Application: SSI 7485

I write regarding the proposed modification to M4-M5 Link, Mod 2 The Crescent overpass and changes to pedestrian infrastructure in North Annandale, Rozelle and Rozelle Bay Foreshore area. *I object to the overpass and to the relocation of the Green Link and*
I request RMS work with the community to explore alternate design options to the proposed new car overpass design and the changed pedestrian and cyclist links. I am seeking the reinstatement of the safe, direct access from the approved EIS GreenLink to create a continuous green open space connection from the Rozelle Rail yards and Annandale to the foreshore. The GreenLink was more than just a walk way - it put people central to the design, maximising safety, and providing much needed accessible open space for the community now and into the future Bays Precinct design.

Figure 4-4 Elevation: Indicative view of The Crescent overpass

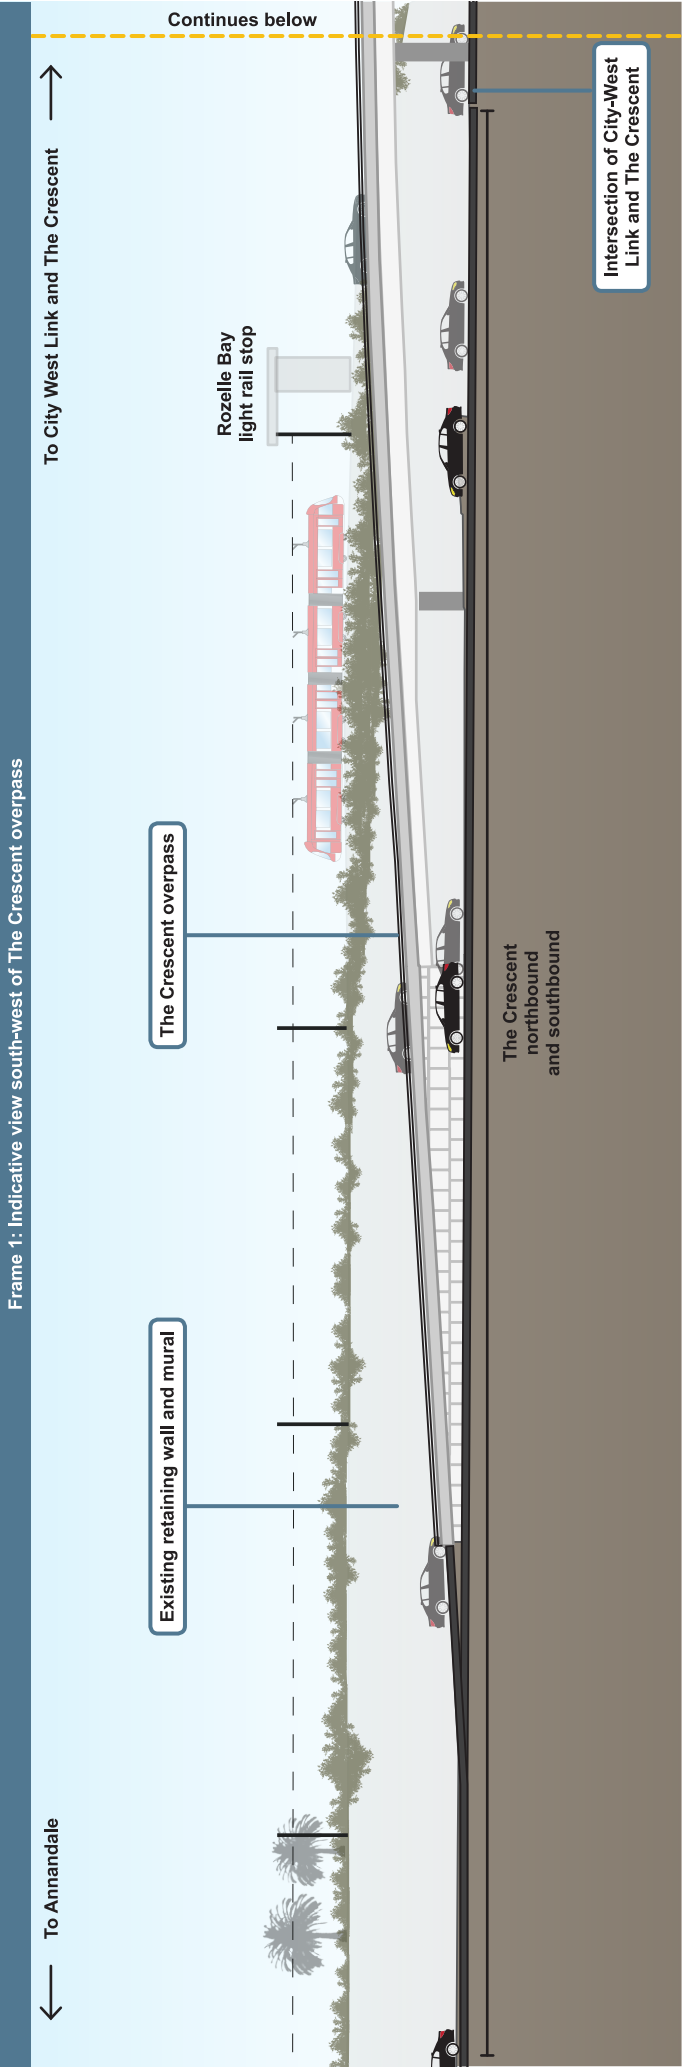
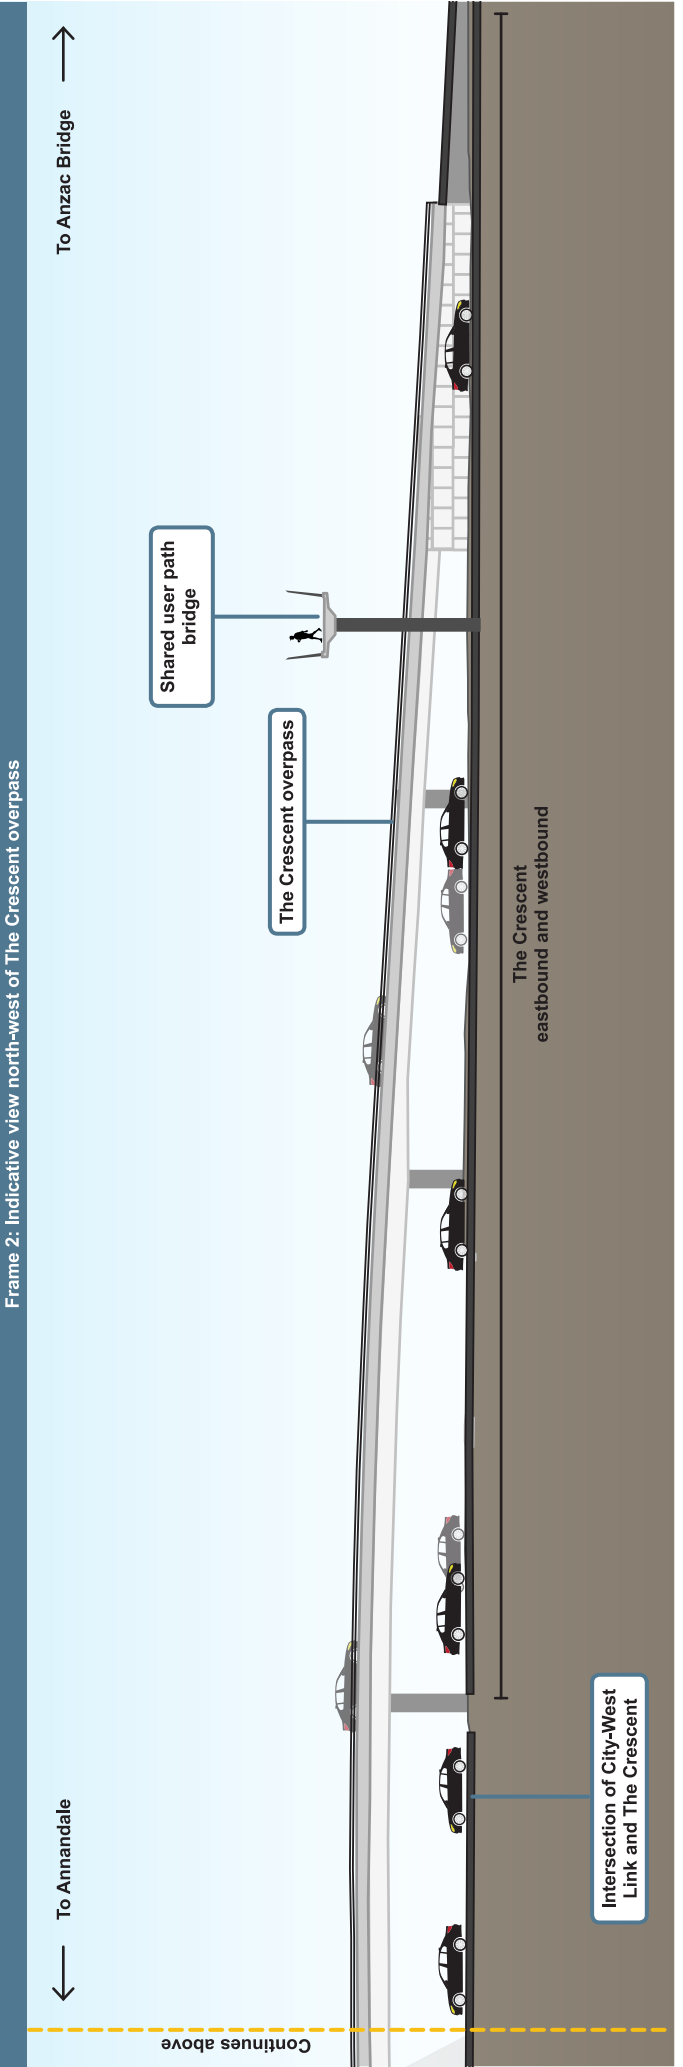
- The significantly reduced safety and increased risk for pedestrians and cyclists with removed access over The Crescent to Bicentennial Park and the increased traffic along Johnson Street.
- Being required to cross five sets of pedestrian lights at The Crescent as my option to reach the foreshore from Annandale or from Rozelle Bay light rail stop.
- Removal of direct active links to the foreshore, cutting the community off from the area and the proposed revitalisation of the entire Bays Precinct, including linking the Light Rail and Bus stops to a Ferry wharf and Metro station.
- Urban and landscape design that is being built before a finalised Masterplan for the area.
- Traffic changes that limit movements around the suburb and create further congestion in the local streets of Annandale, Forest Lodge, Glebe, Lilyfield and Rozelle with no planning to deal with these.

Create an underpass for the cars & give a quality pedestrian / cycle pathway for local residents.
